DEVELOPMENT FACILITATION TEAM

Planning - Case Comments

Project Number: PR-2020-004448

Project Name: Kairos Power, 5201 Hawking Dr. SE

SITE PLAN

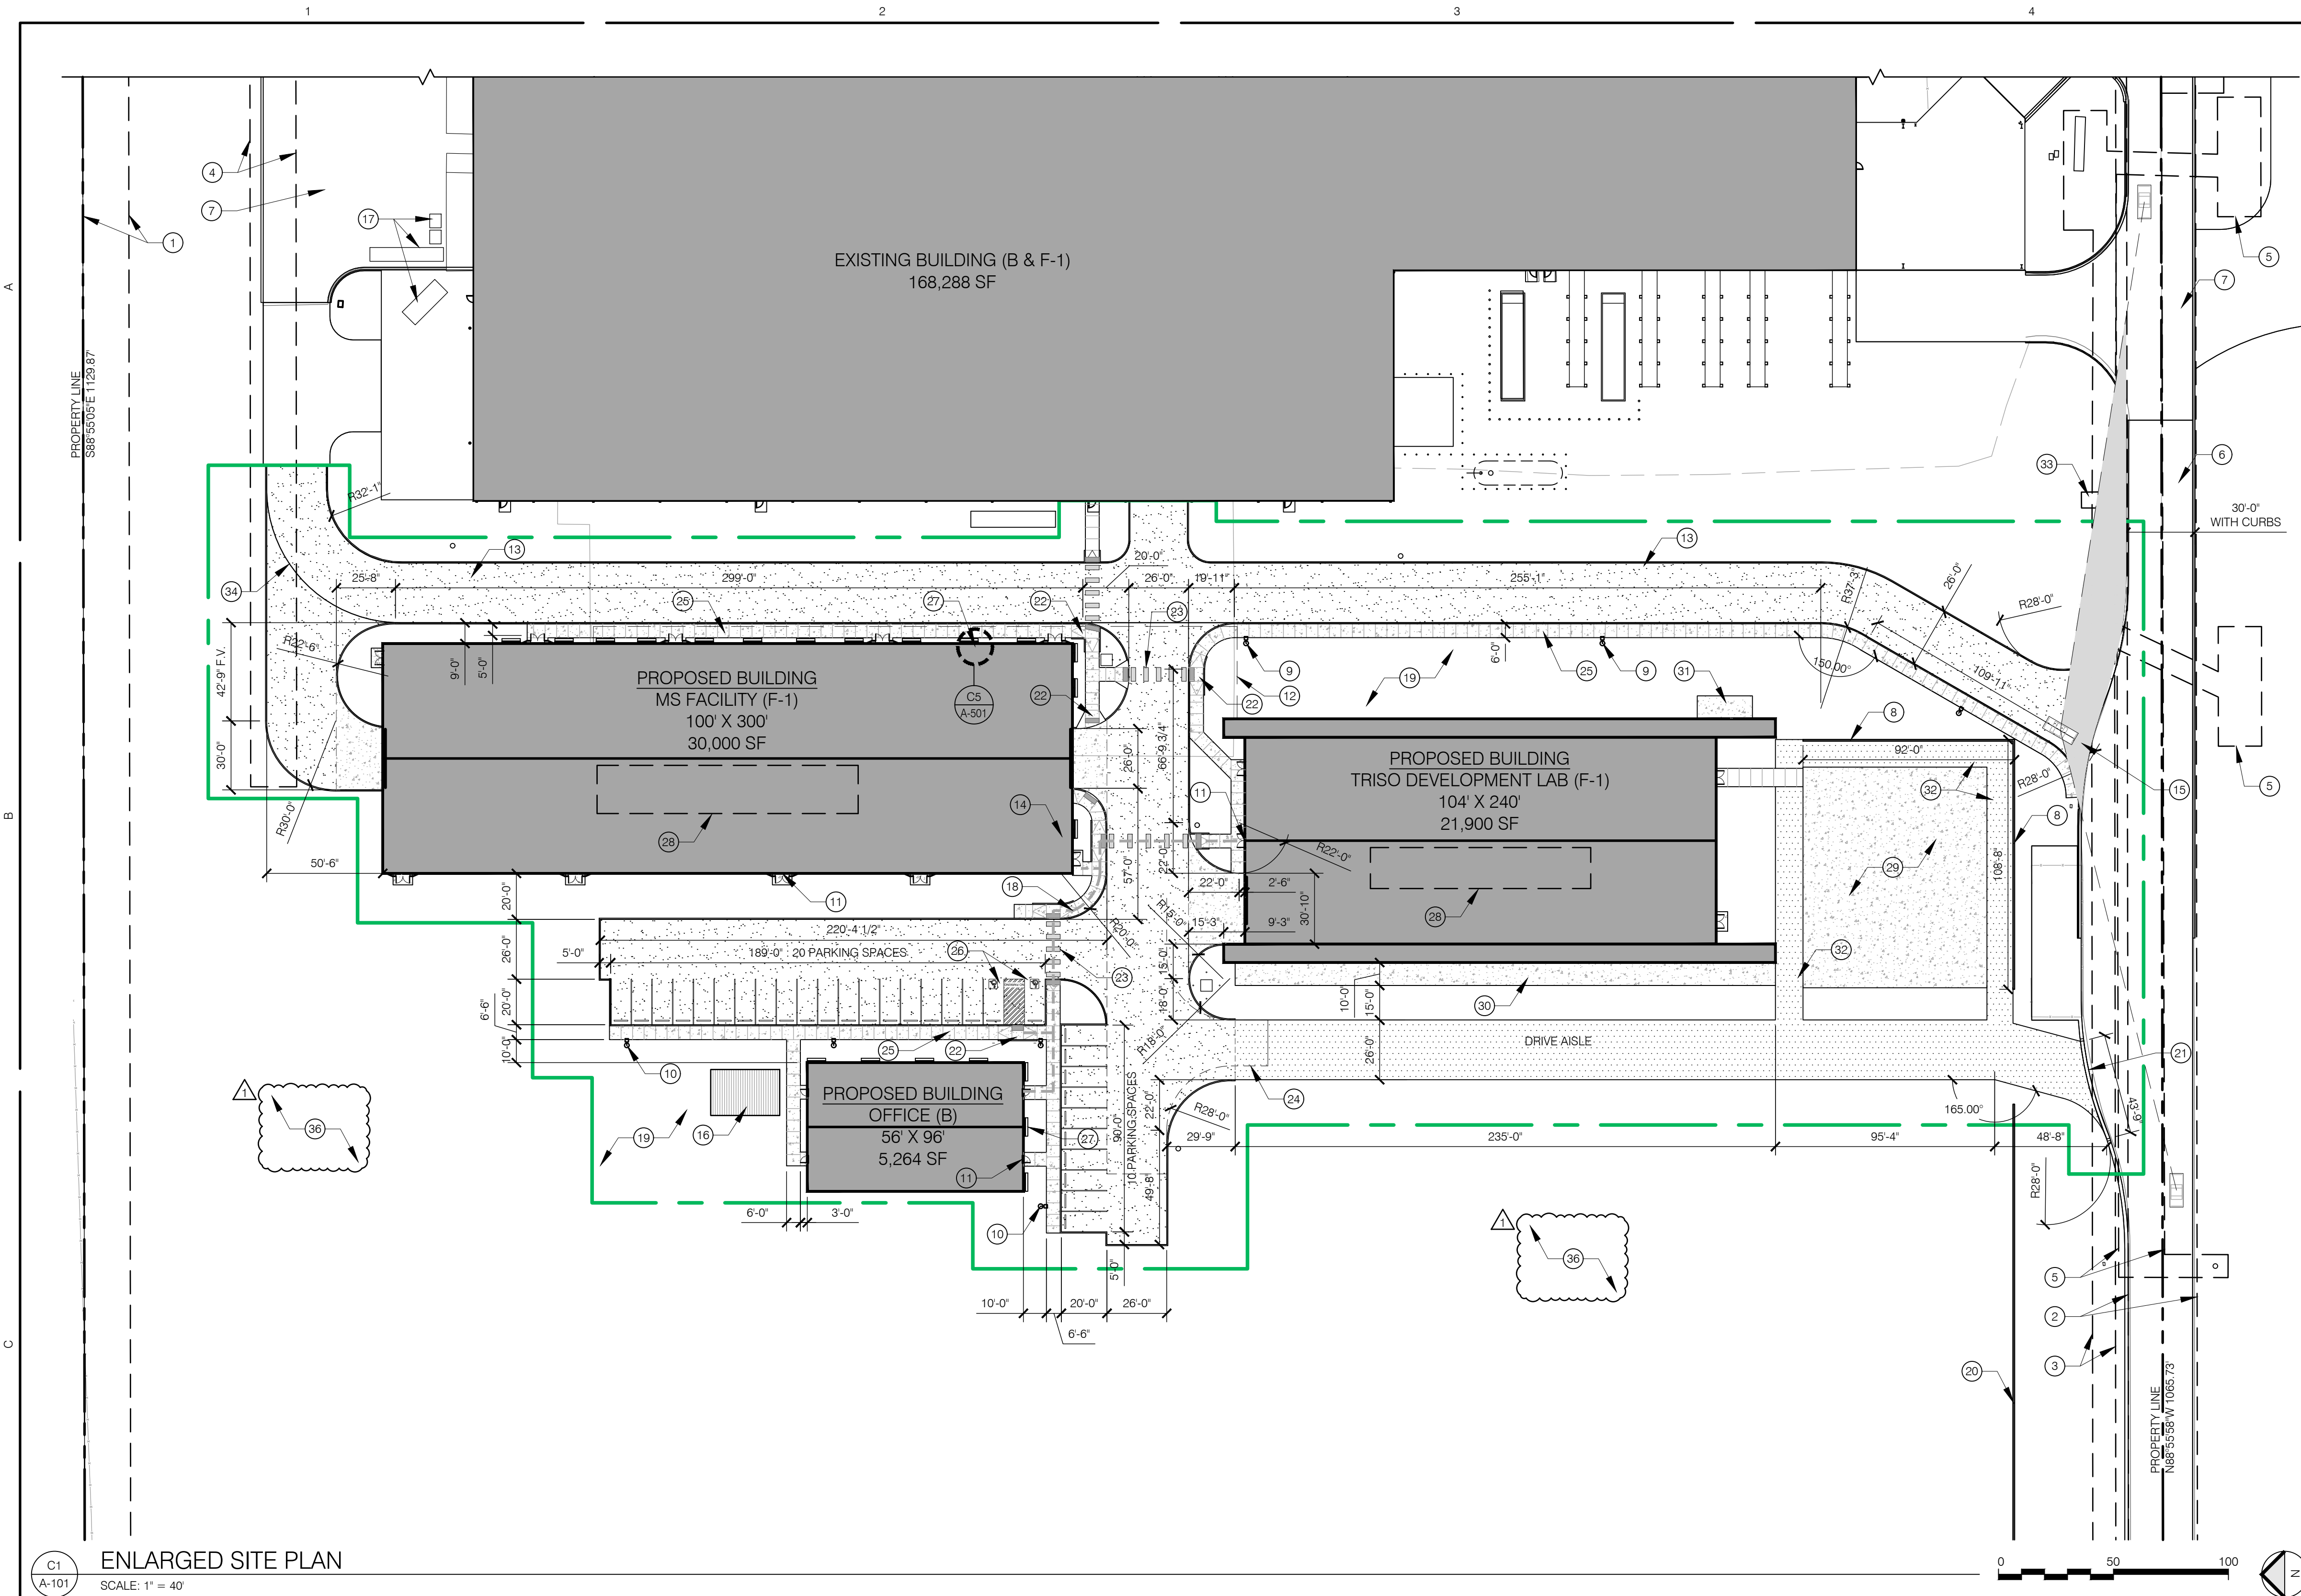
- The signature blocks for the DFT members must be added to the Site Plan (preferably onto Sheet A-100). The DFT signature blocks can be obtained at the following link: https://documents.cabq.gov/planning/development-facilitation-team/Site_Plan_Administrative_DFT_Signature_Block.pdf

The applicant has provided this note at Keyed Note #30 on Sheet A-100.

- Sheet A-101 shows a ‘concrete pad for future exterior equipment’. **Please note that MdS 2.2.4 c. requires that ‘outdoor storage areas shall be screened.’**
- Please note that where the MdS Level B plan is silent, the IDO applies.
- Sensitive Lands analysis is complete and included in this submittal.

- IDO 5-11(E)(3) requires: at least one outdoor seating area that is a minimum of 500 s.f. **Please identify this seating area on your site plan.**
 - The subject site is in the Airport Protection Overlay Zone, which contains applicable regulations. Please refer to 14-16-3-3 of the IDO, starting on p. 65. Height is regulated in this overlay zone.
